Part 5 of the Town & Country Planning (Development Management Procedure) Order 2015
Approval of details reserved by condition imposed under ref. BE/135/18/PL relating to
Condition No. 45 (full permission) regarding levels at the Salt Box site.

Land at Salt Box, West of Shripney Road, Bognor Regis

Arun District Council have decided to **REFUSE details reserved by this condition**

The information submitted regarding Condition 45 imposed on full planning permission BE/135/18/PL: relating to levels at Unit 9, at the Salt Box site is refused and the condition is hereby not discharged.

Drainage Layout
Sheet 1 of 2
- Drawing Status

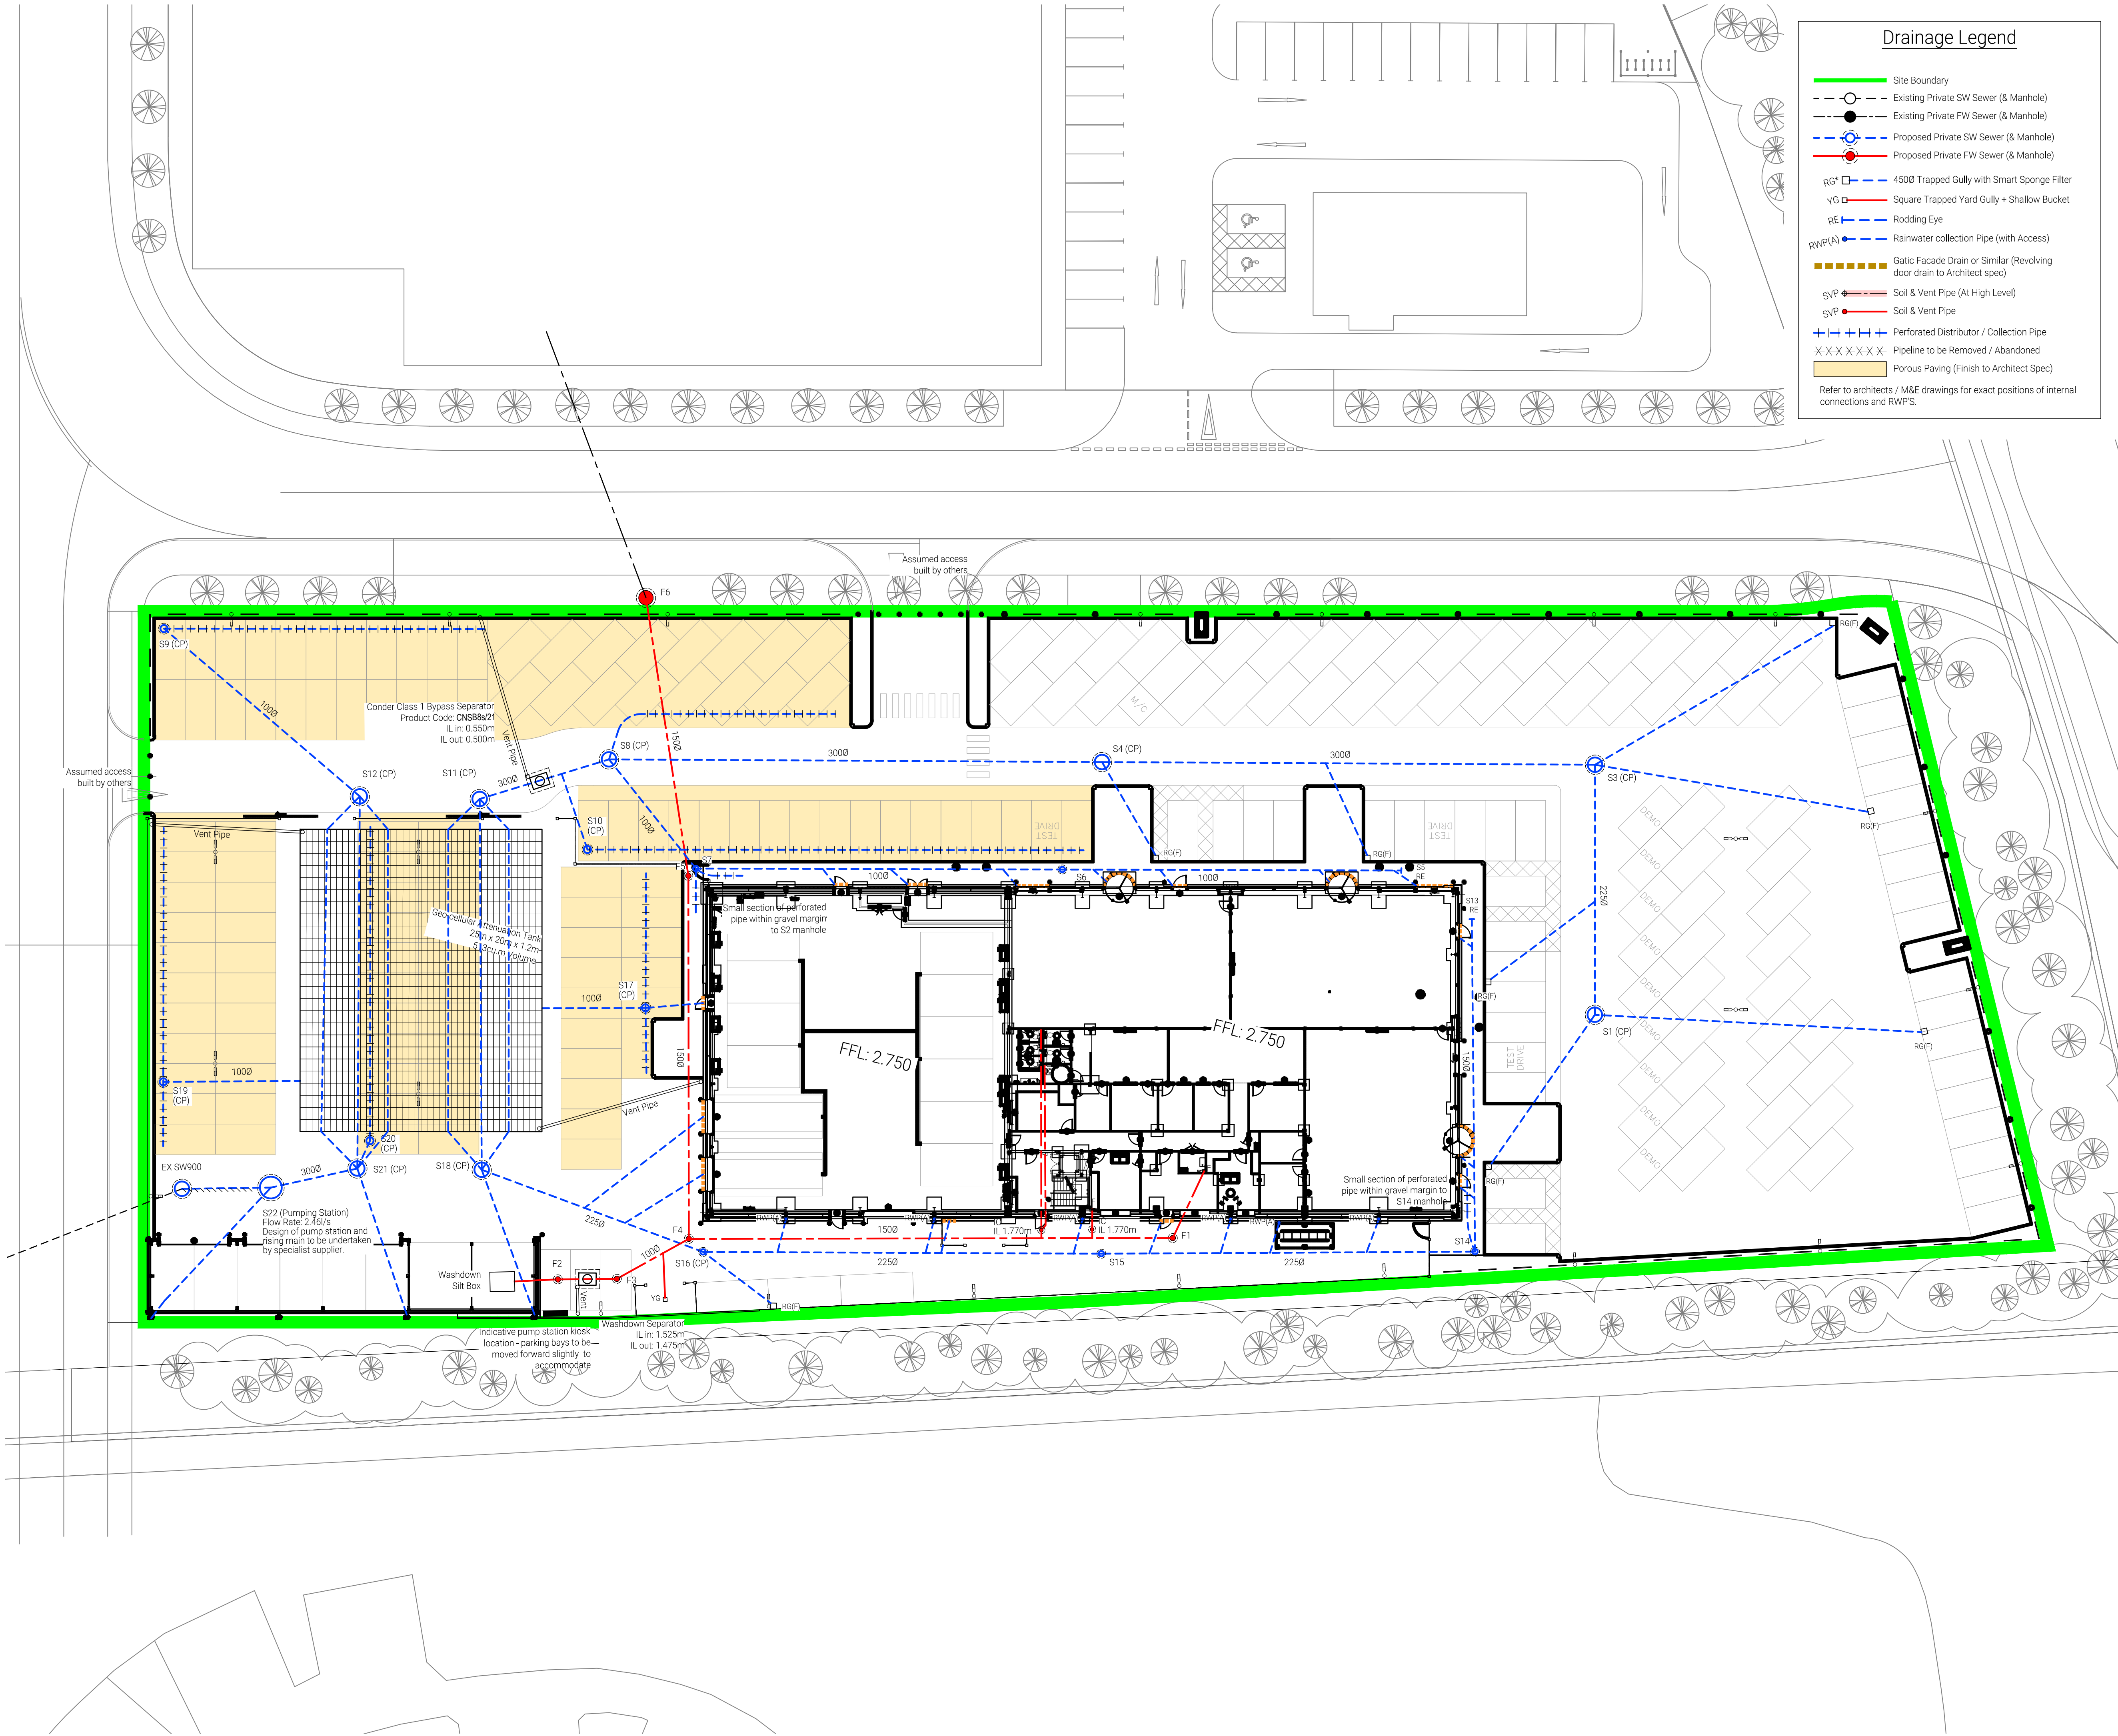
In respect to **Condition 45**, the site levels impact on the site's surface water drainage scheme.

The surface water drainage scheme for Unit 9 submitted under **Condition 12** has been **refused** as it fails to provide a satisfactory solution i.e. a pumping station is being proposed, which is not sustainable and does not align with the envisaged strategy. A gravity solution must be achieved. Any proposal also needs to be supported by relevant hydraulic calculations to prove that the design storm can be accommodated on site. It is hereby confirmed that the proposed discharge rate of 2.46 l/s meets the requirements of the 'Hydrock' overall strategy. The applicant should expand the use of permeable paving where possible to improve water treatment, and this could also aid in providing additional shallow storage. All cover/invert levels and pipe gradients/diameters need to be included on the layout plan.
